September 26, 2023

**Subject: Villas at Aspen Trails Preliminary Plan – Preliminary Comments (SP-23-004)**

This is a request for approval by Kimley-Horn and Associates on behalf of ROS Equity Holding-Independence, LLC., for the Villas at Aspen Trails Preliminary Plan, consisting of 41 residential single-family townhome lots on 4.25 acres. This proposed development is **not** located within the boundaries of the Trails at Aspen Ridge, rather located immediately north and west of that subdivision, southeast of the intersection of Powers Boulevard / State Highway 21 and Bradley Road and east of Big Johnson Reservoir.

OPEN SPACE CALCULATIONS

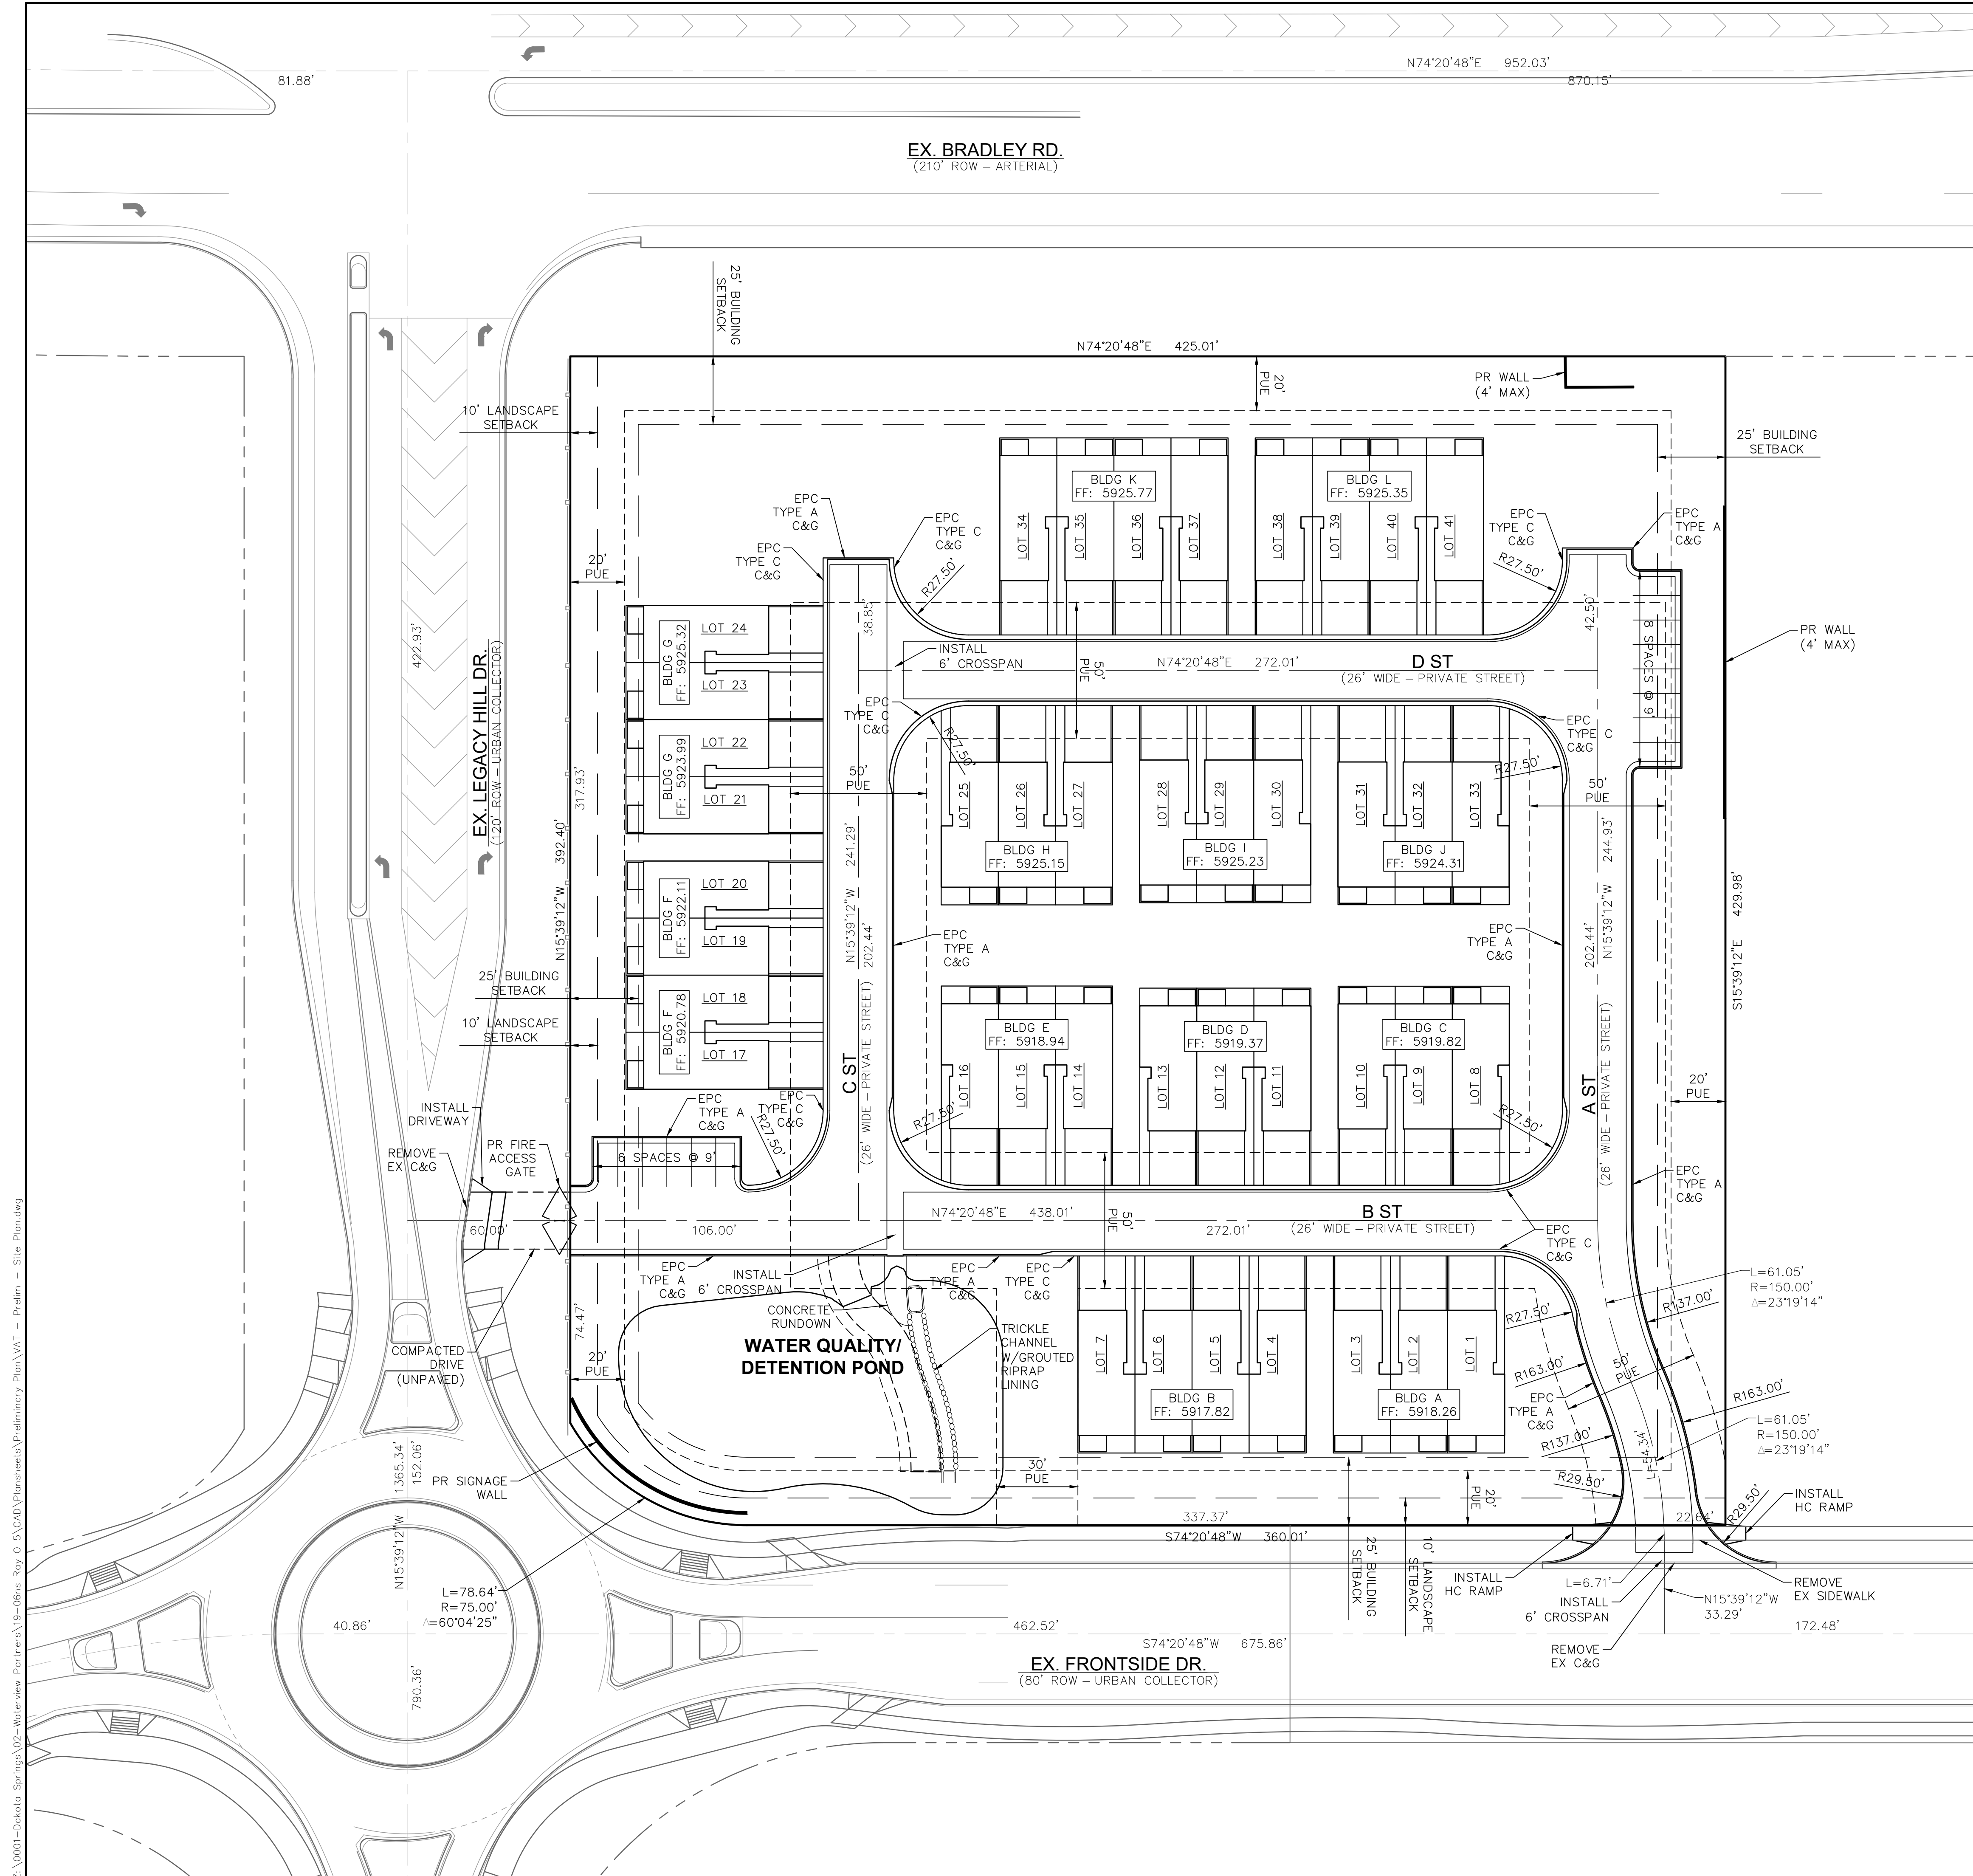
Zoned RM-12 single-family attached residential townhome units, the Villas at Aspen Trails is not required to meet the El Paso County Land Development Code's 10% open space requirement. However, the applicant has included ~2 acres, or 47.1%, of private open space areas within Tracts A and C, dedicated to unspecified open space uses and stormwater detention.

The applicant's Letter of Intent does not outline the intended uses of the open space areas, nor does the Preliminary Plan due to the lack of a landscape plan. Staff recommends that the applicant include a detailed description of the open space uses and include a landscape plan in future submittals of the Preliminary Plan. If no recreational amenities are being considered for the Villas at Aspen Trails, it should be noted that the adjacent Trails at Aspen Ridge subdivision provides publicly accessible recreation through two established neighborhood pocket parks and a planned centralized community park, the latter of which is due for completion in 2025. These parks are located within short walking distance to the Villas at Aspen Trails.

The Park Advisory Board recommends that the Planning Commission and the Board of County Commissioners include the following conditions when considering and/or approving The Villas at Aspen Trails Preliminary Plan: (1) recommend that the applicant include detailed open space descriptions in the Letter of Intent; (2) recommend that the applicant include a Landscape Plan in future Preliminary Plan submittals; (3) fees in lieu of land dedication for regional park purposes in the total amount of \$20,705 and urban park fees in the amount of \$12,423 will be required upon the recording of the forthcoming Final Plat.
